Application for a Non-Material Amendment Following a Grant of Planning Permission

Please describe the non-material amendment(s) you are seeking to make

UNLESS OTHERWISE SPECIFIED		PROG/PRG			
DIMENSIONS ARE IN MM		Draw	Dim	12/23	
DIMENSIONS APPLY AFTER FINISH		Draw	Dim	12/23	
TITLE		SIZE	DWG NO.	REV	
The Warren, 19 Deben Drive		A0	Proposed-01	B	
Sudbury, Suffolk, CO10 2QH.		SCALE 1/100			
					SHEET 1 OF 1

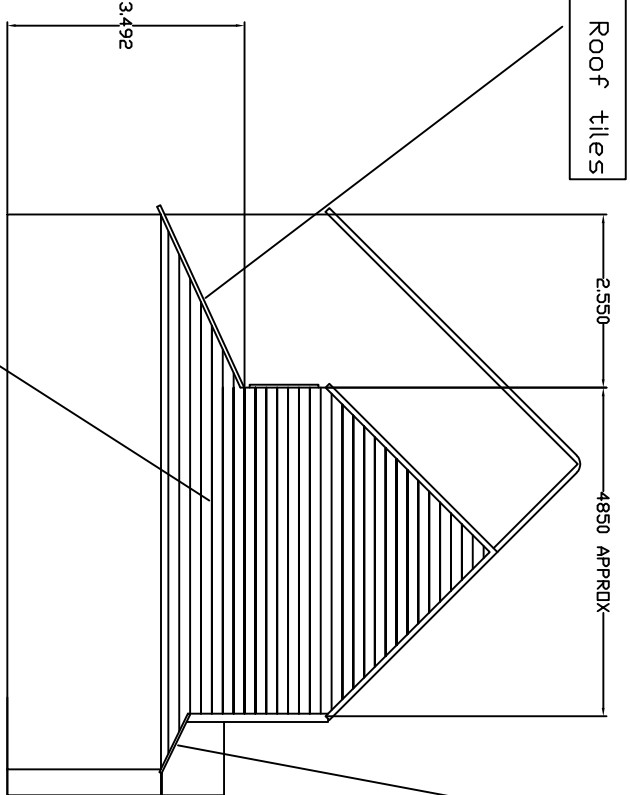
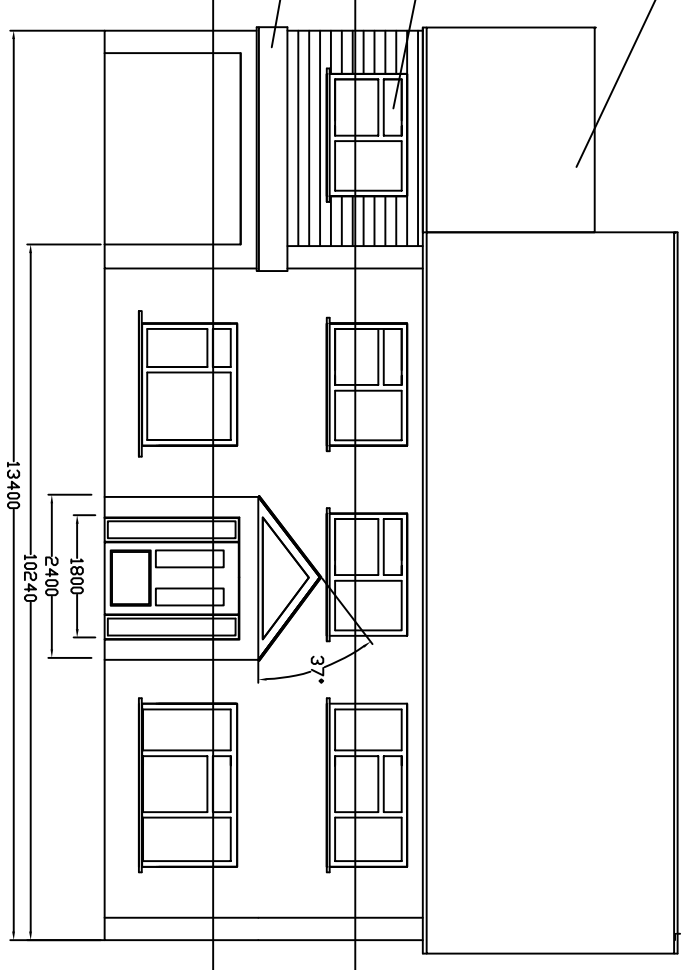
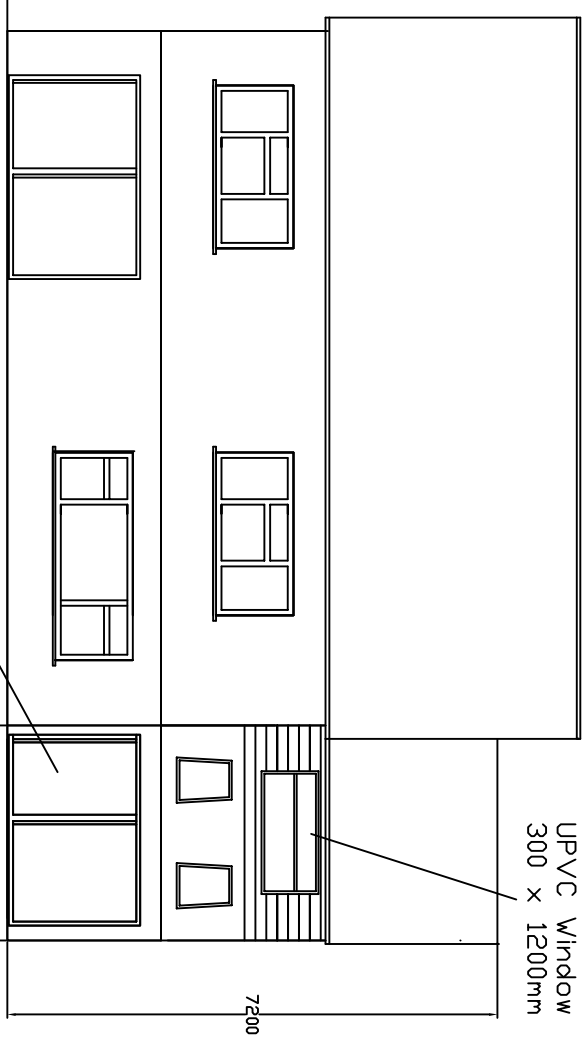
I now have the first floor extension complete and the roof tiles match the existing on the house.

I have noted on the approved plans that the smaller lean to roofs for the garage are "match existing".

I am hoping to fit slate on these two lean to roofs.

I have looked at surrounding building in my street and some just have felt roof garages with another having a different tile to their main roof structure.

The rear of the garden is not overlooked in any way but for your information the annex that I can see from rear garden has a slate roof (3 Park Road Sudbury). They will match these as well as my next door neighbours large car garage at the rear of his property - also slate.

It is now clear that this would be more aesthetically pleasing and match my new front door colour.
